Subject: RE: Fontwell ref.WA/71/18/DOC.

EH has viewed the noise report and updated drawings regarding the above application received to EH on the 13th September 2018 and EH has made the following comments below.

Fontwell noise report comments:

Figure 4.1: Barrier Calculation (excerpt from proprietary Pace Consult barrier calculation sheet)

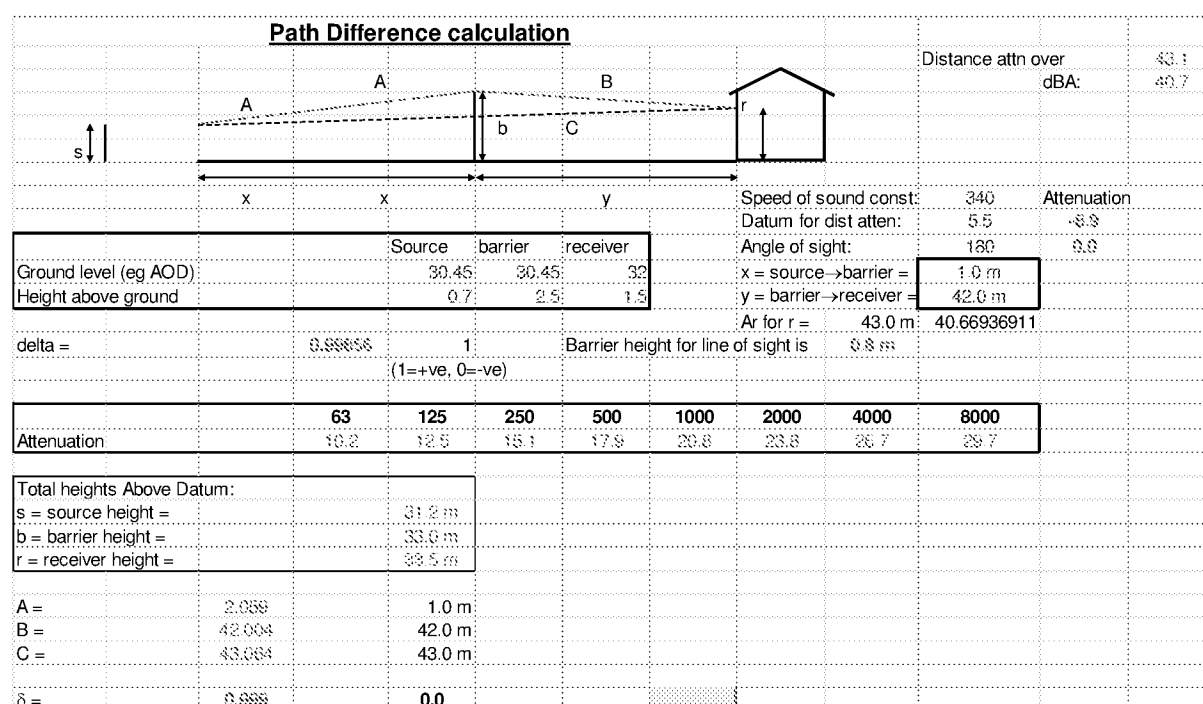
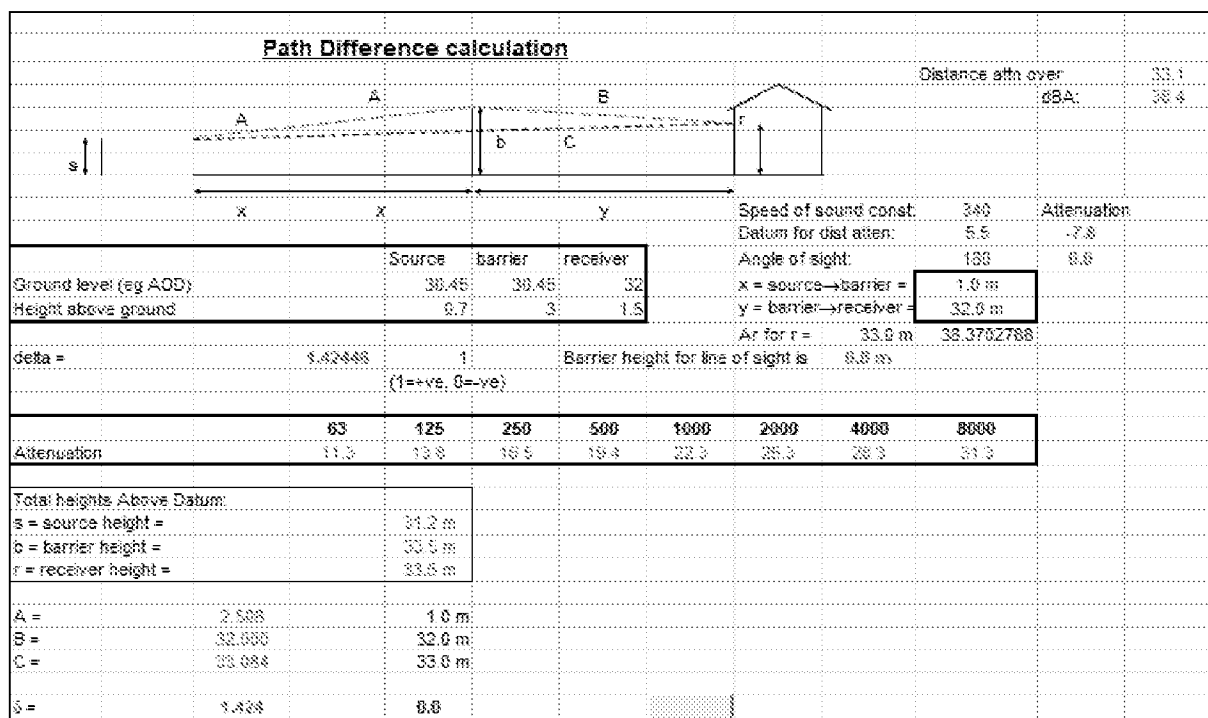
8. With regard to the acoustic barrier, the residential properties to the north and west of the site are located higher than properties to the south. We have concerns therefore that the barrier would not prove as effective as the applicant may have intended.

8. As long as the barrier obstructs the direct line of sight between the equipment and the noise sensitive receptors (which it does by far) then noise will be reduced. We are confident that the fence will provide adequate attenuation.

In order to provide sufficient air flow around the units the layout has been slightly amended and to assist in omitting the allowance for vegetation, it is proposed to increase the height of fence from 2.50 to 3.00m and this forms part of the revised report which supersedes that previously submitted.

Figure 4.2: Noise barrier location.

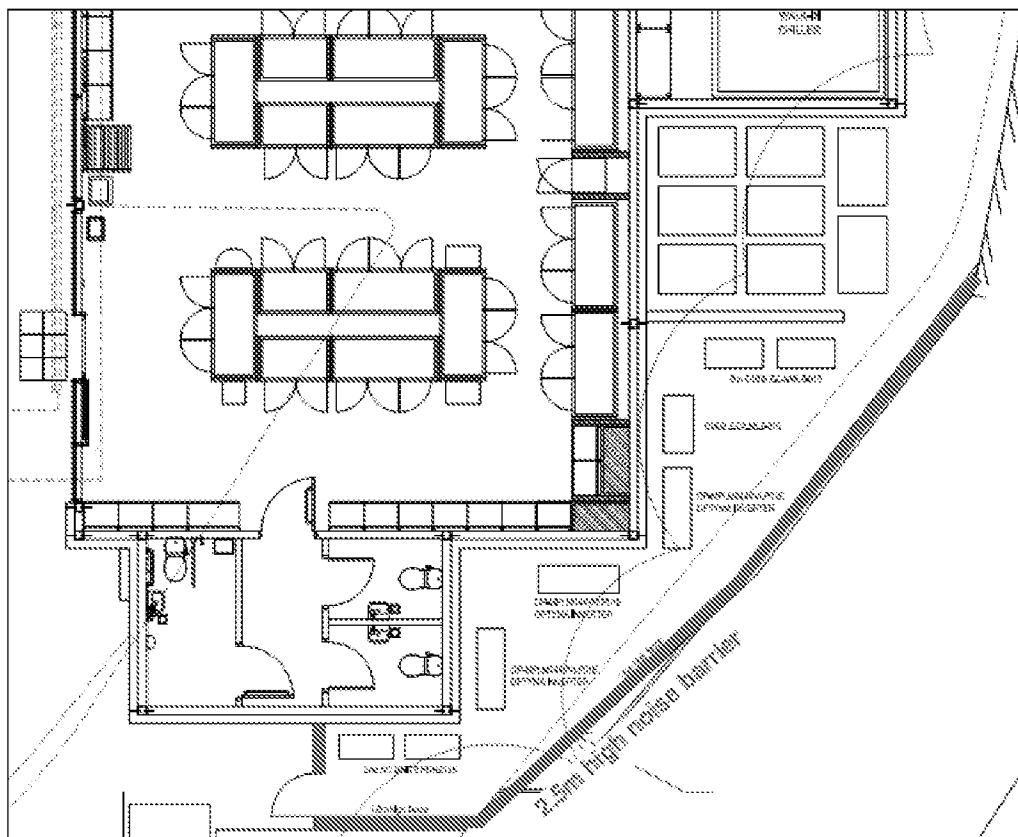
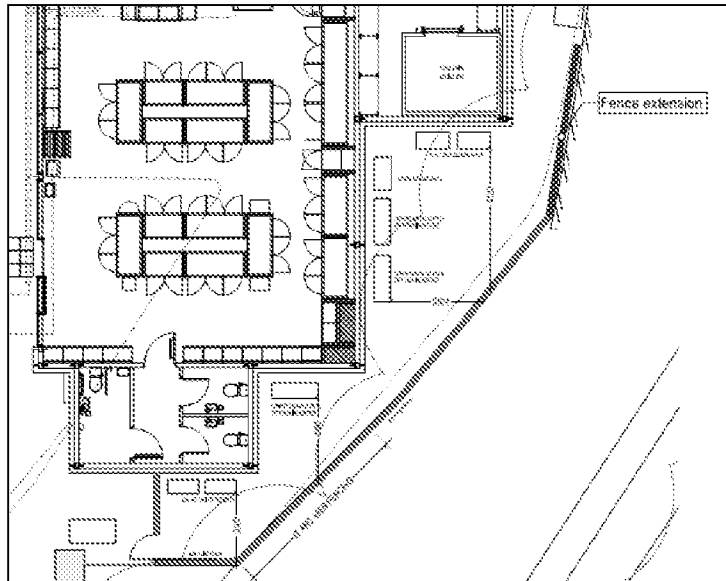
7. Please could the applicant provide the specific location of the acoustic fence. We note that this is shown in Figure 4.2 on page 11 but it is not clear how this ties in with retaining wall in this location.

6. Sound pressure levels produced by this unit are considered to be negligible by our noise consultant.
7. The acoustic fence will overlap and abut the brick retaining wall and be extended along the top of the wall as illustrated in the attached revised report. There will be no gaps in the fence or between the fence and wall.
